REPORT UPDATE

Application No: EG/57/16/PL

Recommendation Report for Planning Permission

PROPOSAL: Medical centre with pharmacy retail unit & other ancillary uses together with access onto Barnham Road & associated car parking. This application is a Departure from the Development Plan.

Landscape proposal plans

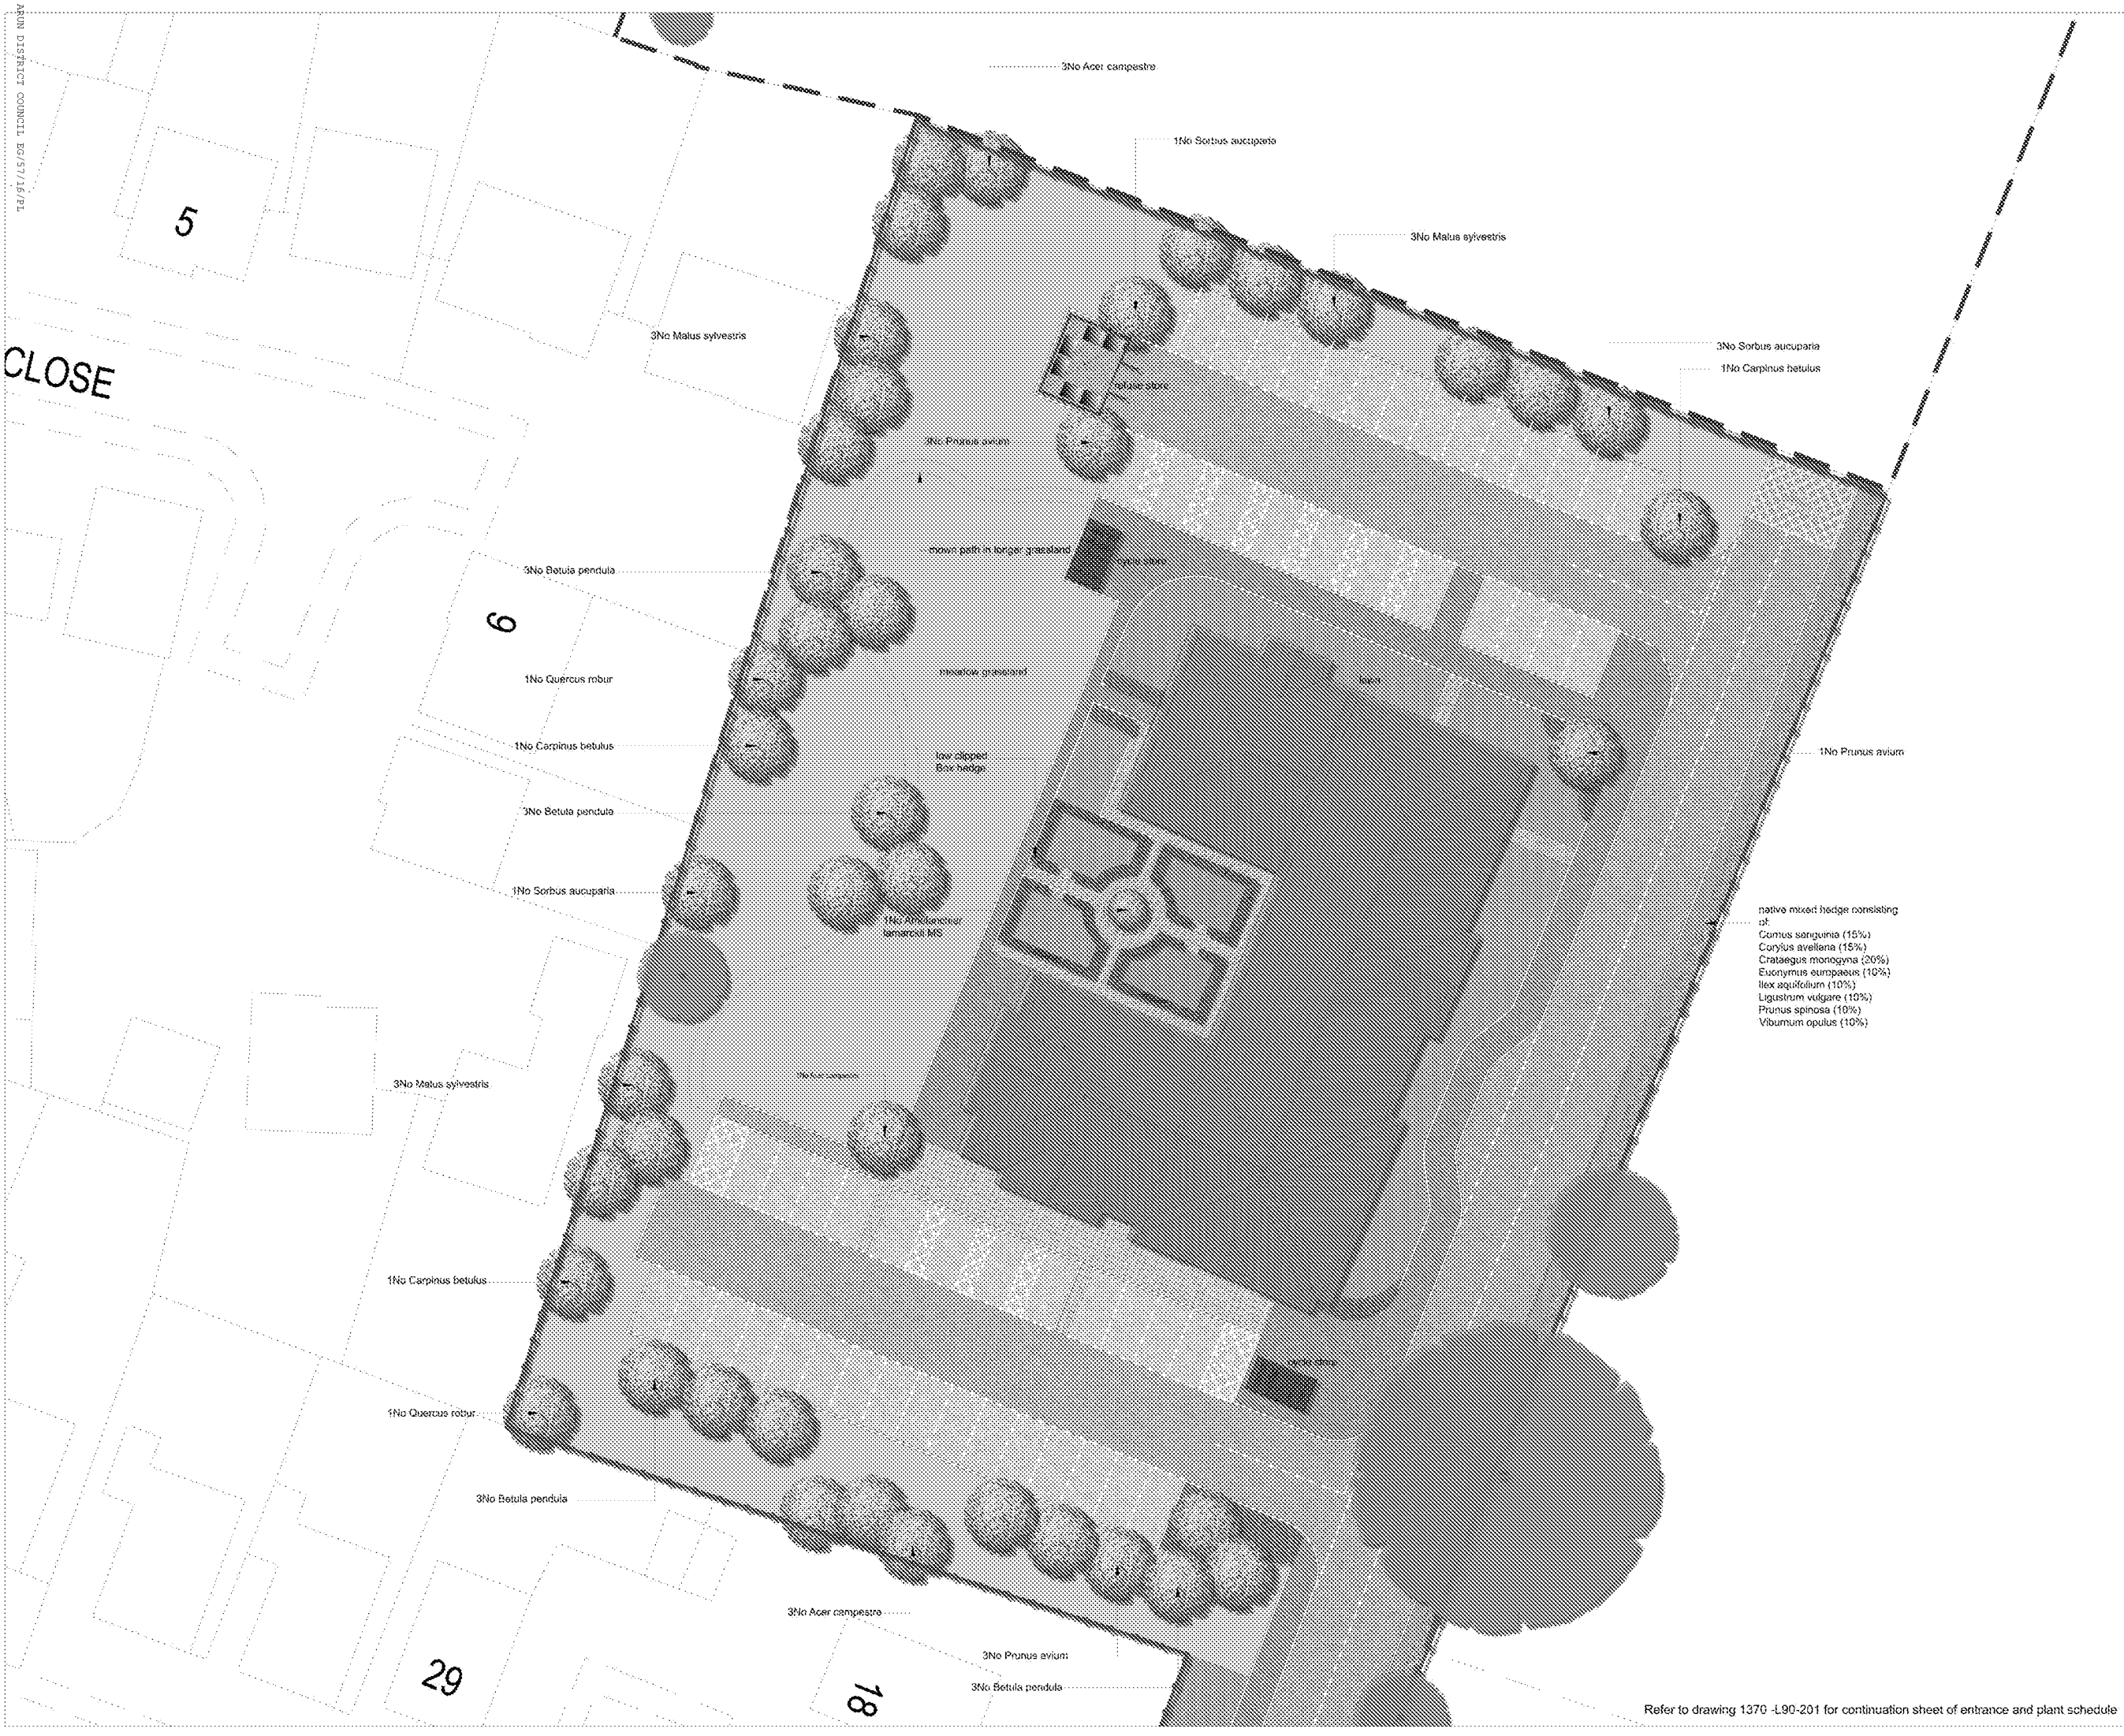
A full landscape scheme should be submitted for approval, detailing species choice, position, densities and size at time of planting. This should be plotted in plan and list form and in relation to the trees and

vegetation to be retained so that a clear picture of the proposals can be seen. These details are required to assure the adjacent properties privacy is maintained and the surrounding landscape is uncompromised. The landscape details dwg L90-200 and dwg L90-201 shows this in some detail but in indicative form only, further plan detail with annotation would be required. The privacy and views of the adjacent existing properties have the potential to be compromised by the proposals and full consideration of mitigation planting to offset the impact should be considered within the landscape design.

TITLE			
Tree Protection Plan Eastergate			
SIZE	CAGE CODE	DWG NO	REV
A3		TP 2160/1704/TPP	
SCALE	1:200	22 Apr 2017	SHEET

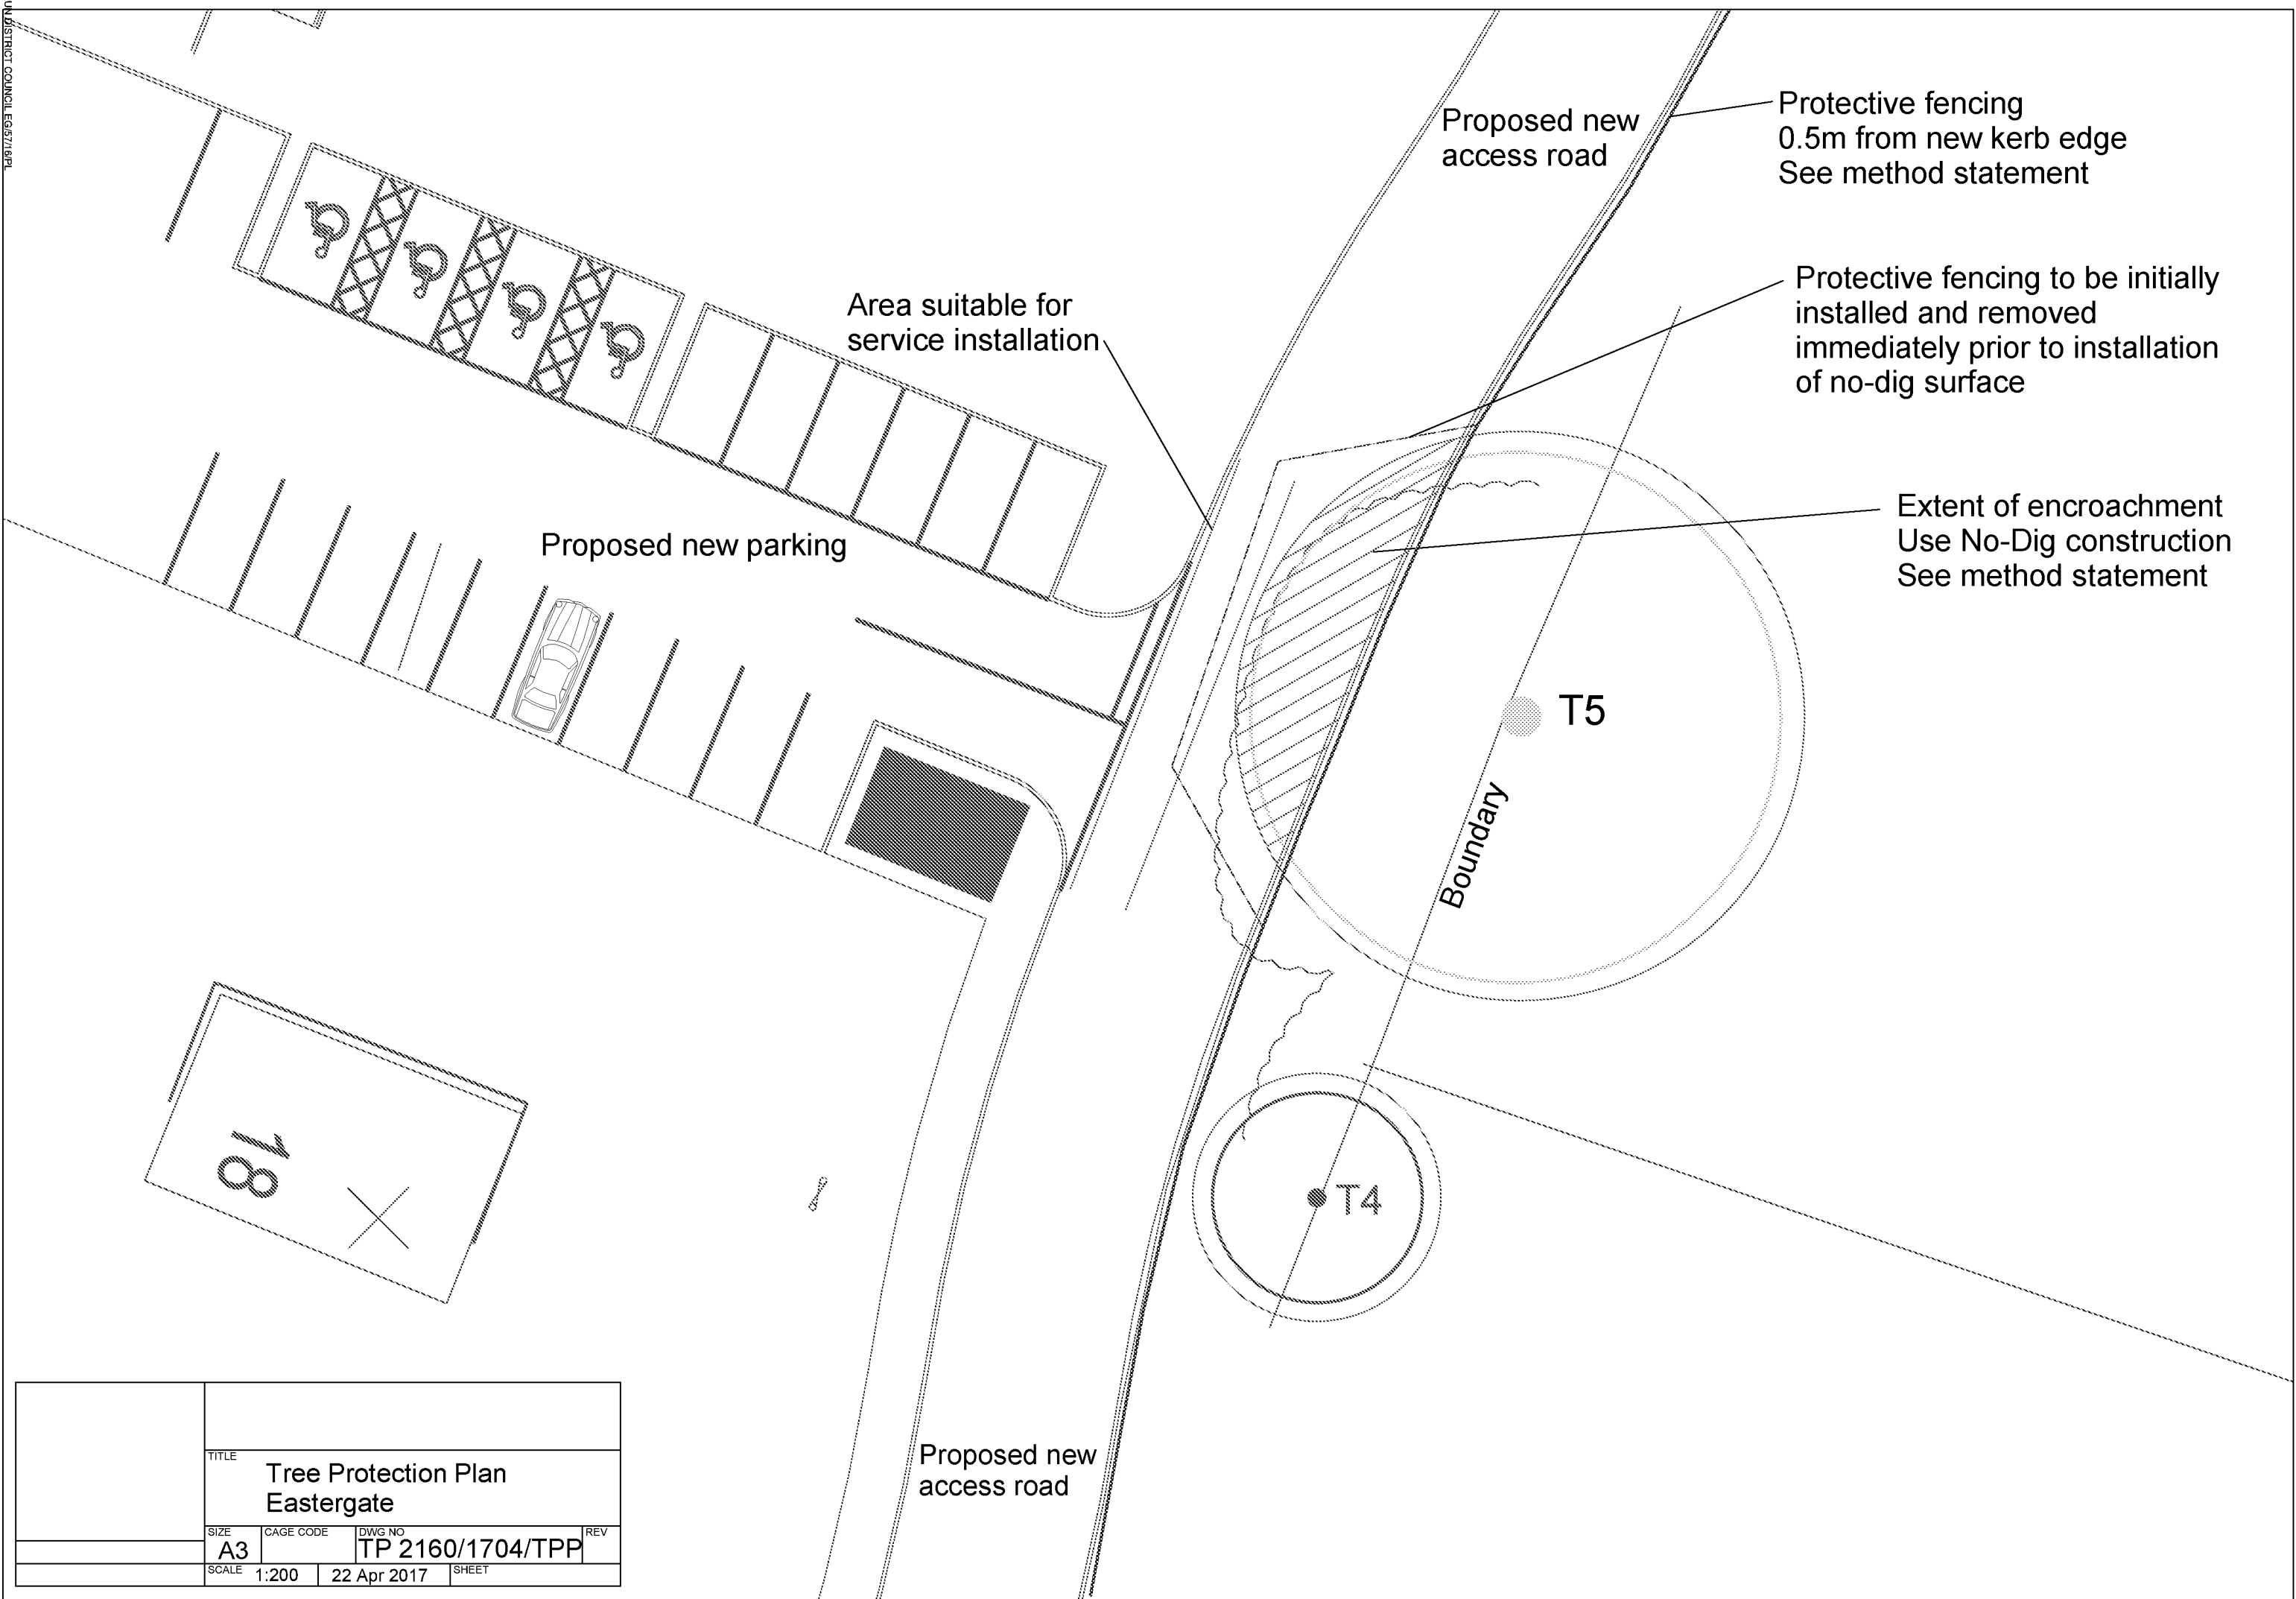
- * Dense brambles and understorey vegetation prevent full access to the trunk of the Oak T5 but 800mm is a fair assessment of its diameter which would give it an RPA of 9.6m.

- * I am not happy with the relationship of this tree to the proposed development and in particular the access road which cuts right through the RPA. I see no need for this when there is adequate space to keep outside of the RPA altogether.

- * I am disappointed to see that instead of looking for a solution by revising the layout to accommodate the tree as per BS5837 recommendations they have sought to apply mitigation measures with a 'No Dig' solution - this in my opinion is 'making it fit' the original layout rather than adjusting same and designing out any conflict with the tree.

- * The Tree Survey report is brief but acceptable and the Constraints Plan likewise but sadly it has not informed the design and the proposed access road cuts right through the RPA exceeding the maximum of 20% of hard surfacing within an RPA advised under BS5837 and having the potential to have a serious and damaging effect on this fine specimen Oak tree.

In response to the Tree Officer comments, the applicant has written to say that their advice (from their consultant) is that the scheme, as amended, is perfectly acceptable in arboricultural terms in relation to the Oak tree. They note that further changes could be made to the scheme to further distance any development from the tree but that this would have implications for other elements of the development.
